CITY OF ALBUQUERQUE

June 9, 2021

**RE: SAMS Academy
6441 Ventana Rd. N.W.
Grading & Drainage Plan
Engineer's Stamp Date: 05/22/21
Hydrology File: A10D010**

GRADING PLAN

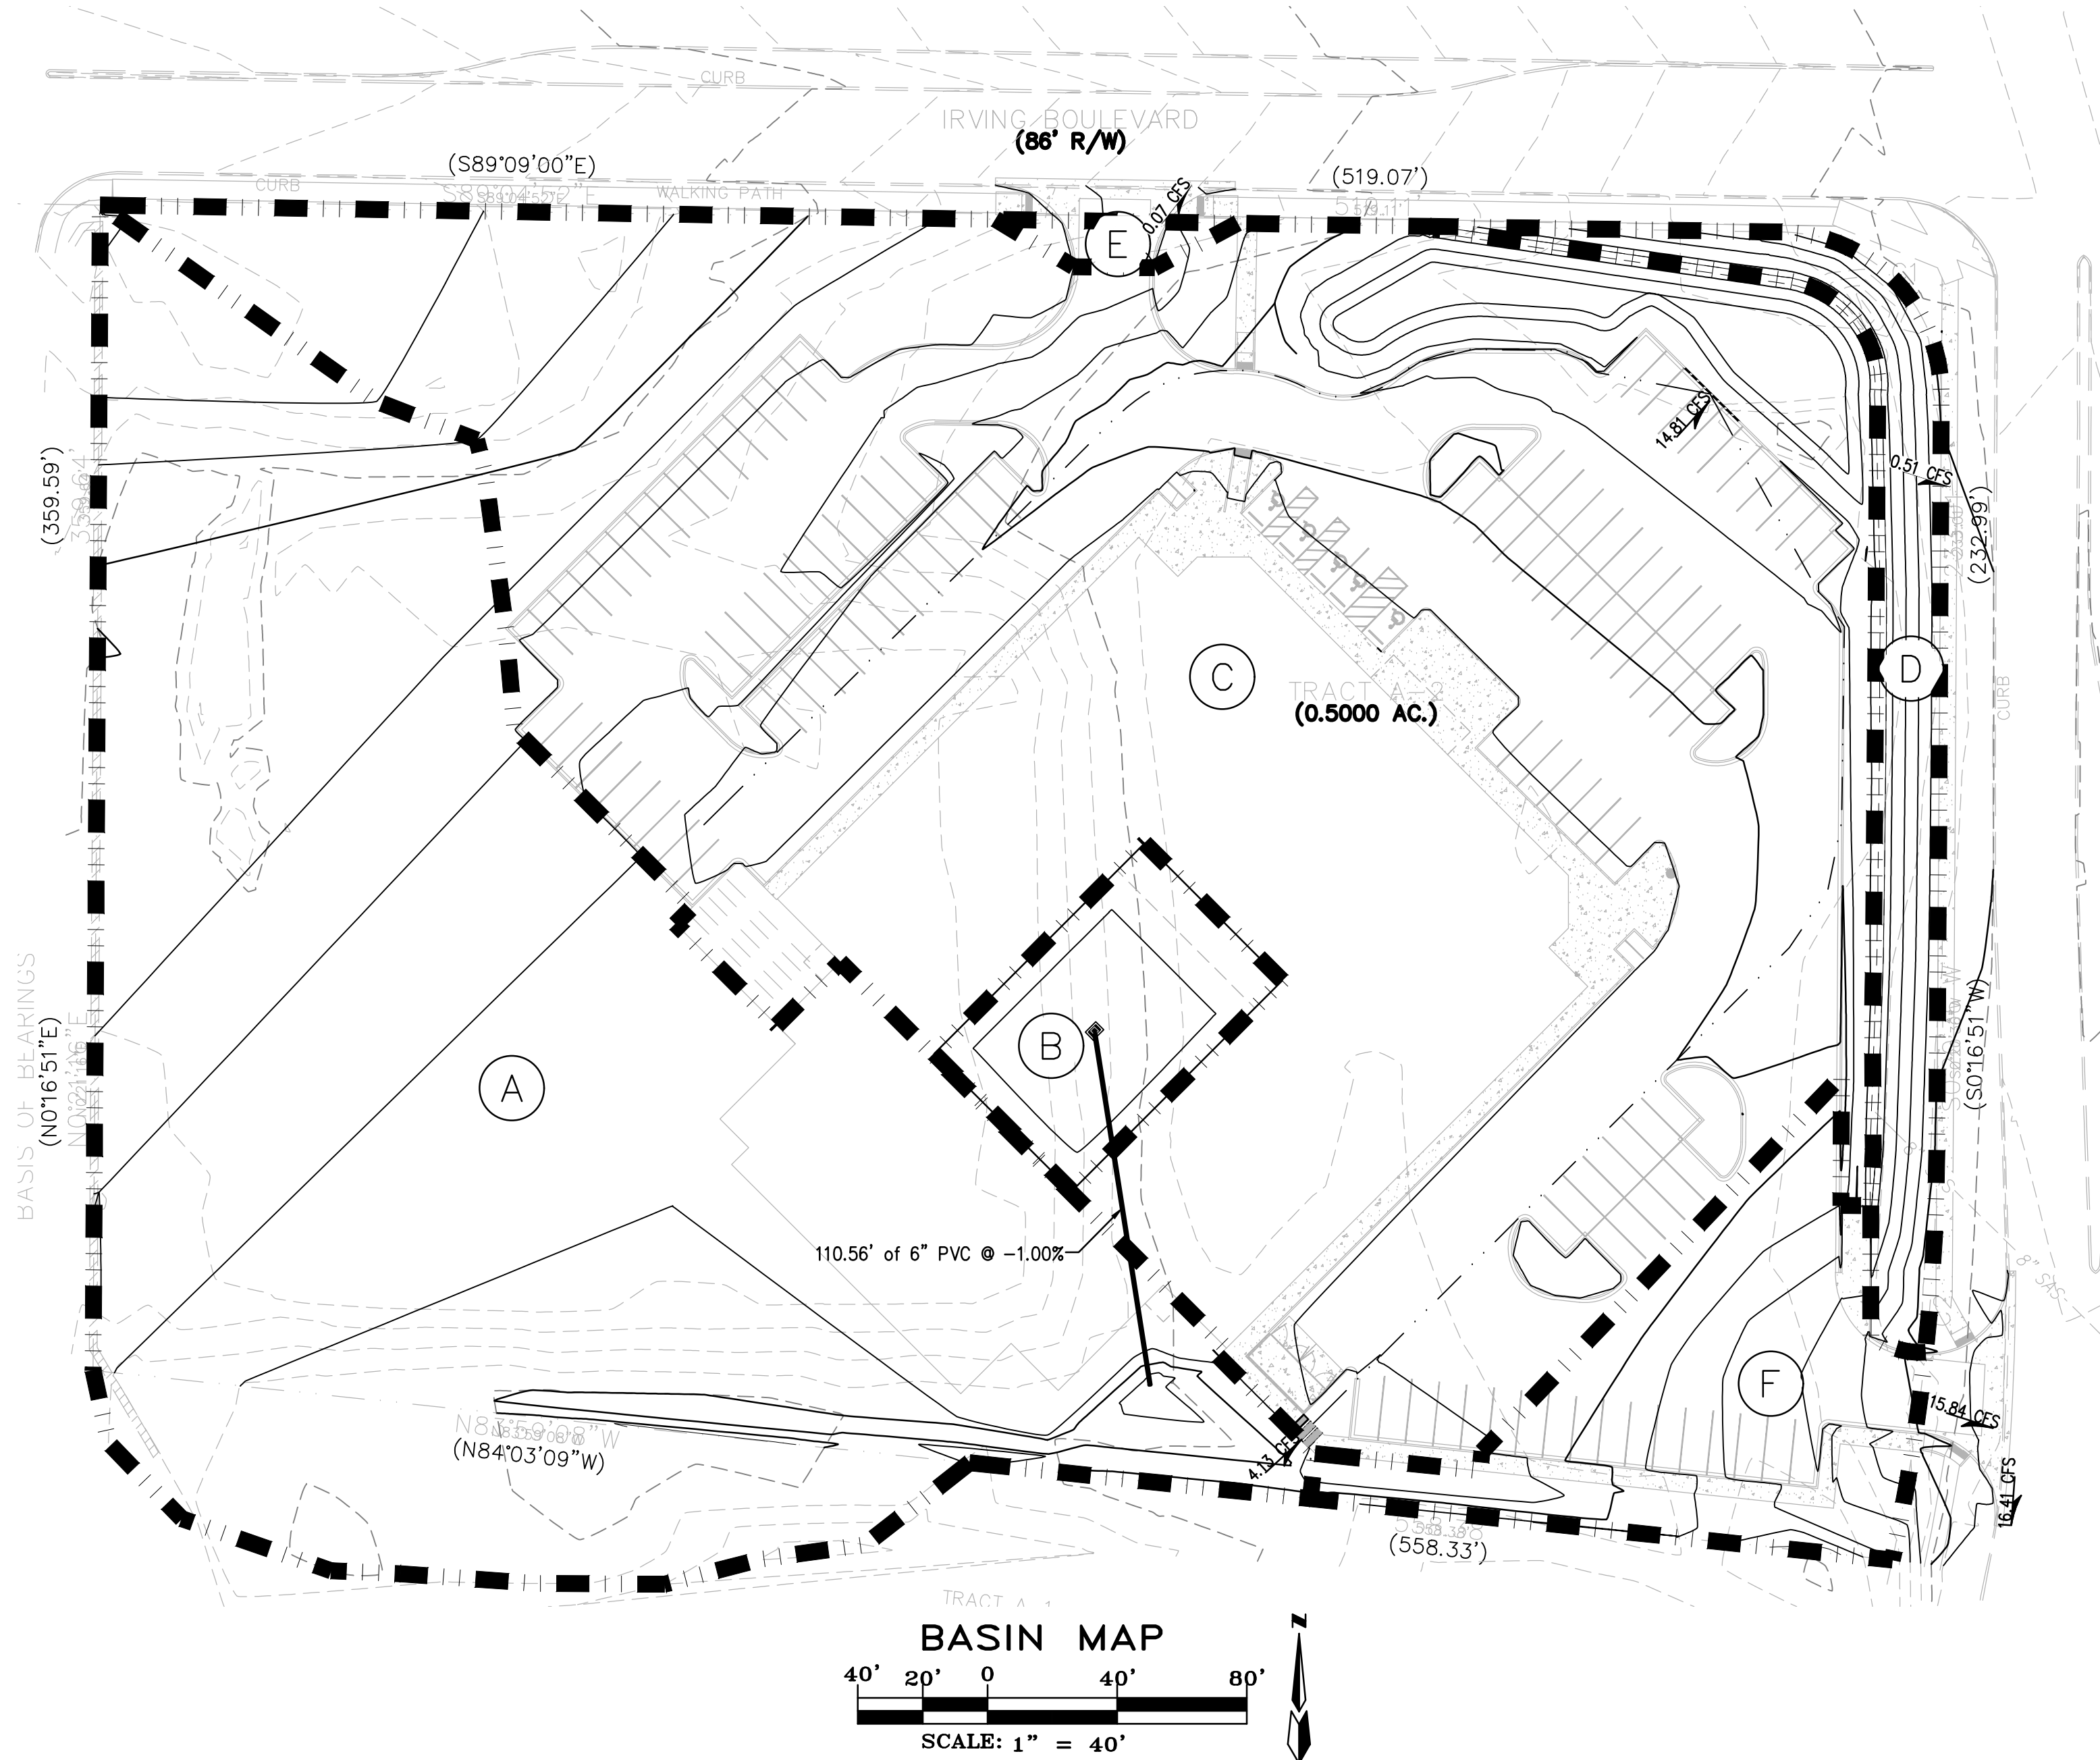
1. Sheet C1. Please just show the building outline. I do not need to see the rooms inside the building on the Grading & Drainage Plan. (See image on Comment #2 below)
2. Sheet C1. Please show the curb along the proposed sidewalk next to the building. This needs to look like all the other curbs that you have. With only a single line, it appears that the sidewalk is at the same elevation of the asphalt.

3. Sheet C1. What is this area at the northwest corner of the proposed building? If part of the building, than see comment #2. If concrete, than please provide a few grade points and label it.

4. Sheet C1. Please show and label the existing asphalt trail along Irving Blvd. Also please note that there will be no grading within the R.O.W. so please terminate the grades at the property line at the same existing grade line.

5. Sheet C1. Going off the proposed grades, there are six drainage areas with their own discharge points. (See photo below). Also please check with the architect to where the building's downspouts will be so that you can better determine what impervious area needs to be included. I have labeled them A – F. I will start off with the easiest drainage area E (the drive pad on Irving Blvd). This area is mainly from the waterblock to the property line and is mostly impervious which can freely discharge to Irving. Drainage area A (this is mostly type C but may have some of the building impervious runoff) has a point discharge into the City's Open Space property. This will need to detain the difference between the existing runoff and the proposed runoff onto this property. Drainage area B appears to be a portion of a courtyard within the building which does go to what appears to be a stormwater quality pond but this appears to then discharge down the south side of the property to Ventana Rd. This area will need to meet the allowable discharge rate of 3.93 cfs/ac. Since most of this area is type C I think it may be able to

achieve this. Drainage area D appears to sheet drain to Ventana Rd. This area will need to meet the allowable discharge rate of 3.93 cfs/ac. Since most of this area is type C I think it may be able to achieve this. Drainage area C is the biggest area but also is mostly impervious. Since this area needs to meet the discharge rate of 3.93 cfs/ac, I believe that the detention pond may not be big enough. And lastly drainage area F is entirely impervious and there is no stormwater quality for this drainage area and if this entire site is to freely discharge into Ventana Rd., then the discharge rate that drainage area C can add to this will have to be calculated by adding the drainage area C and F together to determine the allowable discharge and then subtract the free discharge of drainage area F. Please correct all calculations showing these six drainage area and show the proposed drainage map with the drainage areas and discharge for each area. You may also need to show the existing drainage areas as well, since this also looks to have at least two area on it, on draining onto the City's Open Space and the other onto Ventana Rd.

6. Sheet C1. Please add the grade point at the east waterblock of the drive on Irving Blvd.
7. Sheet C1. Please provide the drainage calculations for the detention pond for drainage area C as outlined in Development Process Manual (DPM) (signed 06/08/20) Article 6-2(a).
8. Sheet C1. Please provide the weir calculations, per DPM Chapter Article 6-16(A), for the curb cuts and sidewalk culverts. A coefficient of 2.7 is typically used for the weir equation $Q = CLH^{2/3}$.
